Response to Planning application from Hertfordshire County Council (T and CP GDP Order 2015)

District ref: 6/2020/2581/FULL
HCC ref: WH/3817/2020
HCC received: 18 December 2020
Area manager: Matthew Armstrong
Case officer: Ania Jakacka

CHANCELLORS SCHOOL PINE GROVE HATFIELD AL9 7BN

AMENDMENT: Laying of grasscrete for the provision of additional car parking and laying of tarmac pedestrian path. (Temporary period of three years).

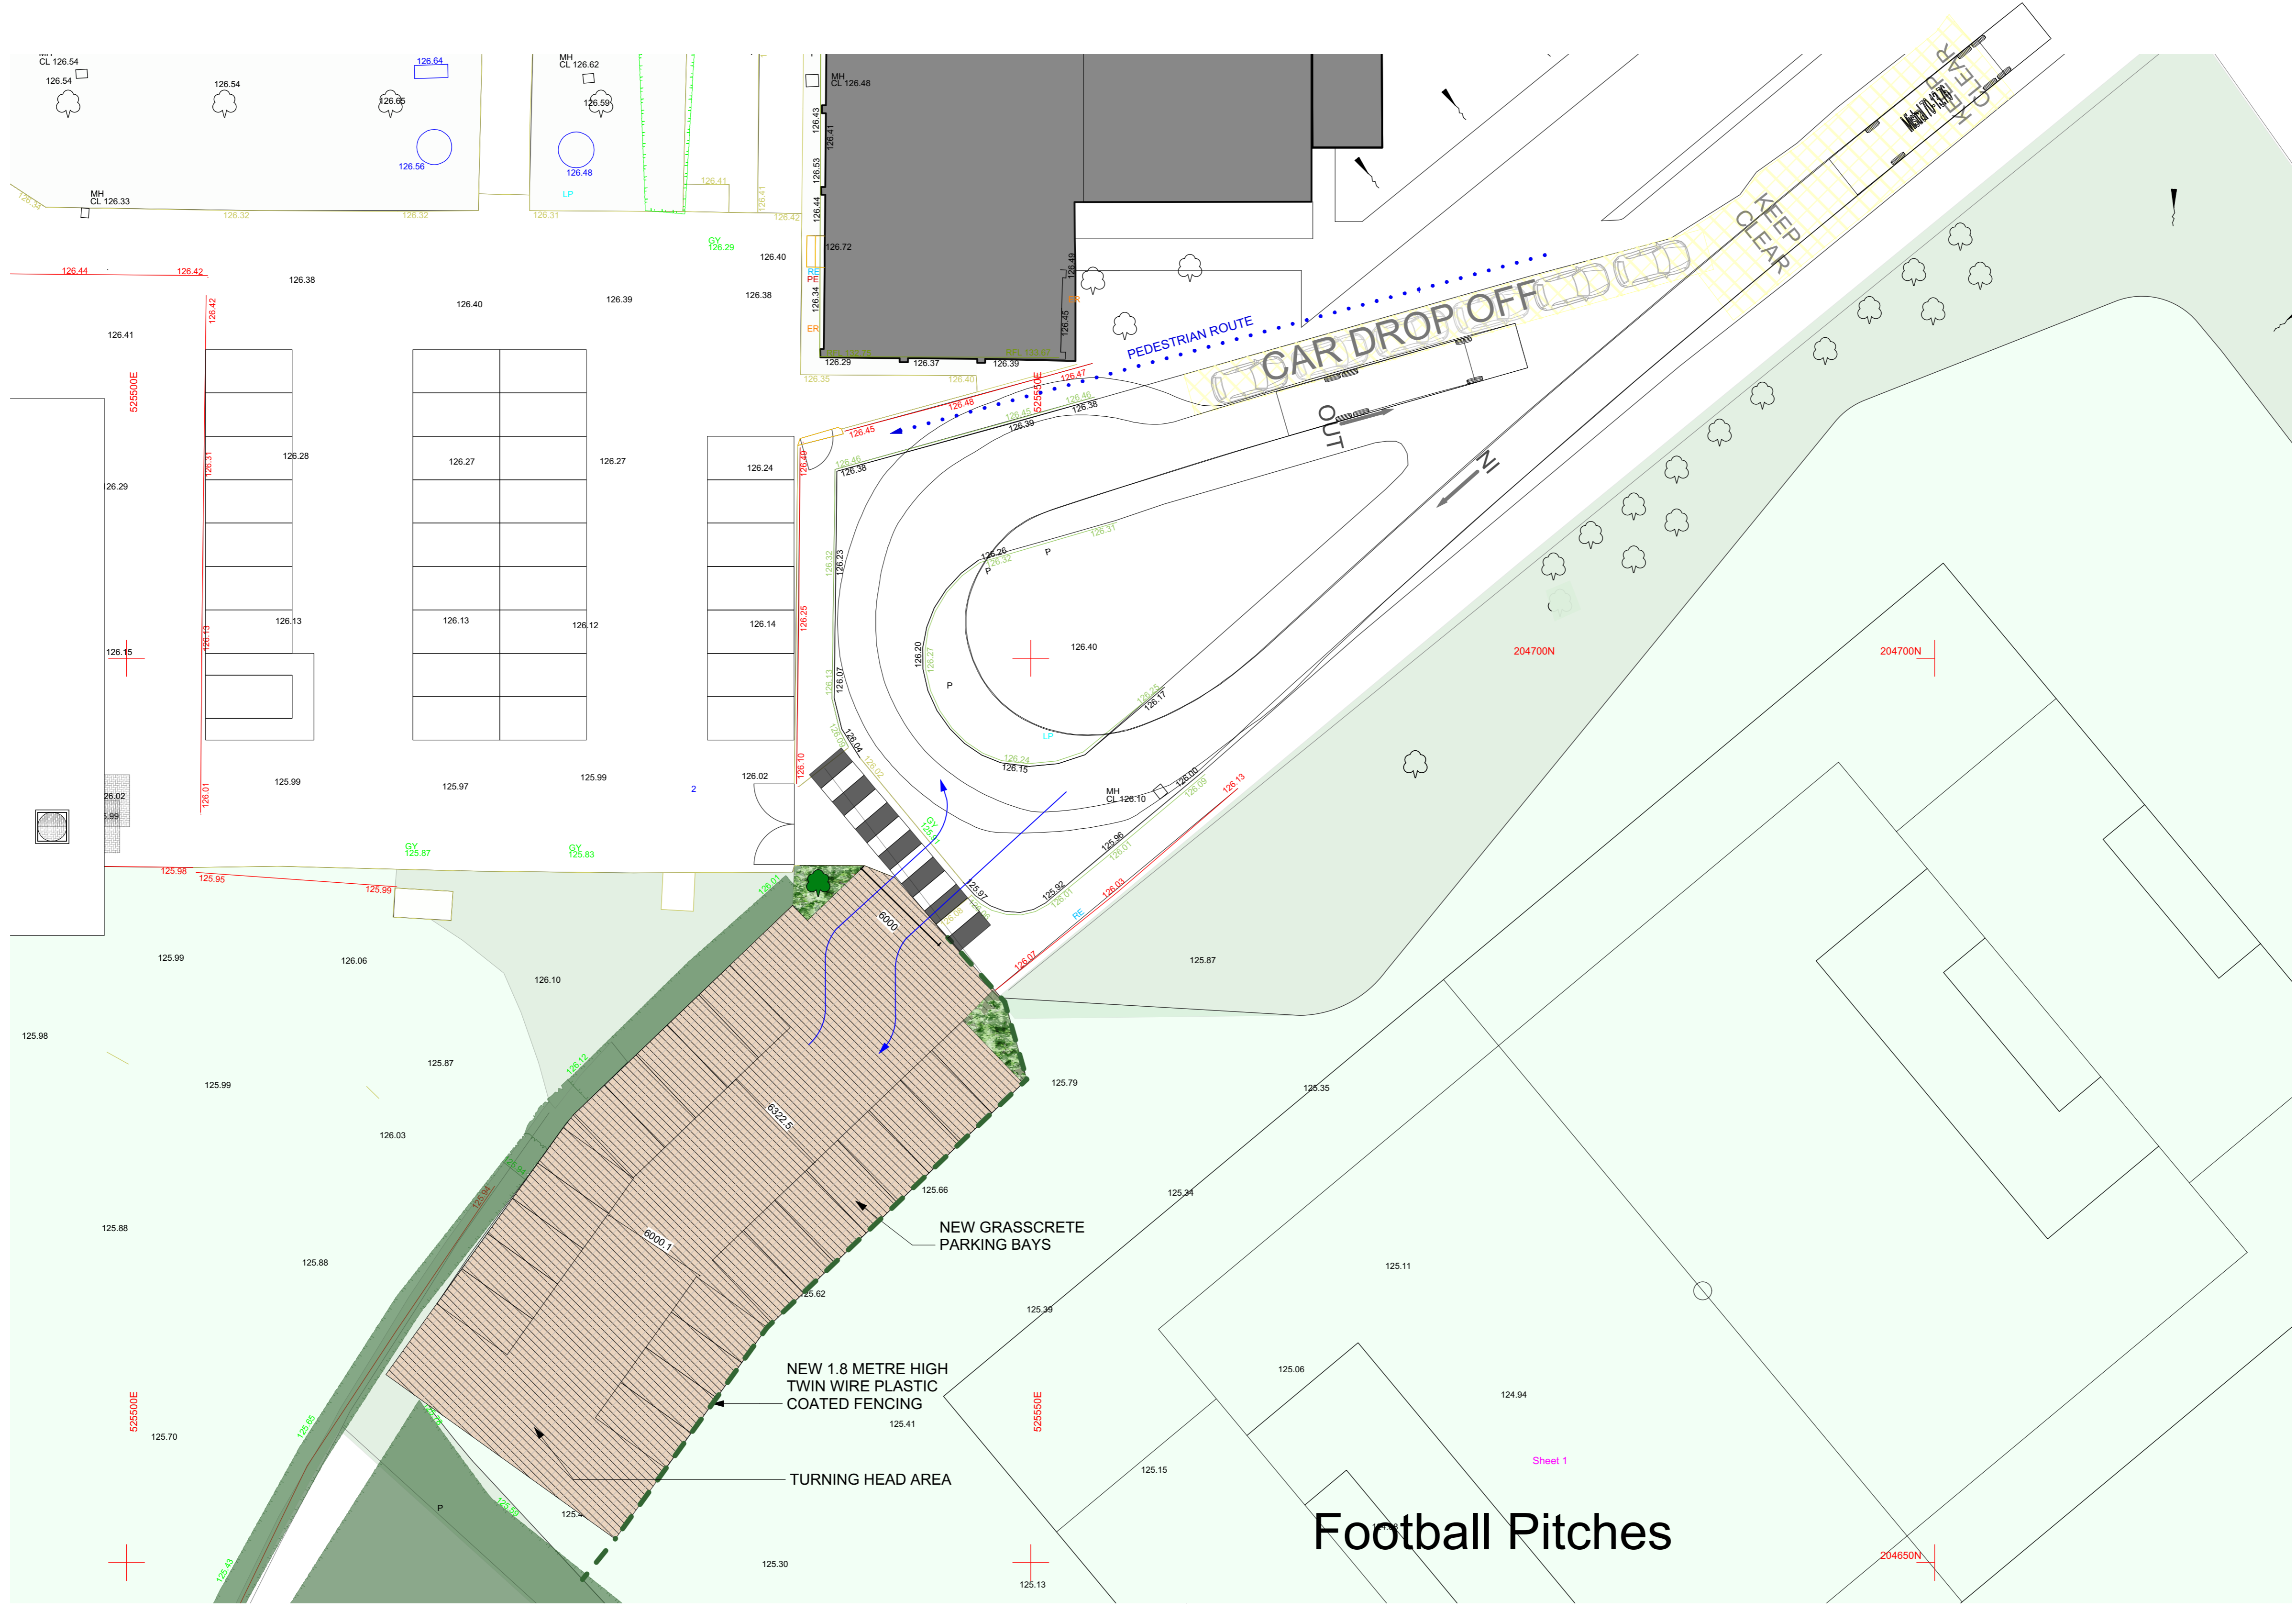
Whilst the Highway Authority raises no objection in principle to the temporary parking being provided as a way of alleviating a temporary issue with parking, concerns are raised with the design of the western car park and lack of reversing space and interference of the new seven "car drop off" spaces with the bus access/pick up/drop off.

For this reason, vehicle swept paths will be required to demonstrate that vehicles will be able to access and turn around and leave in a forward gear the new 27 spaces located in the western car park without the need to reverse out blindly onto the zebra crossing. A single deck bus swept path would also be necessary to confirm that it can continue to use the one-way system unobstructed.
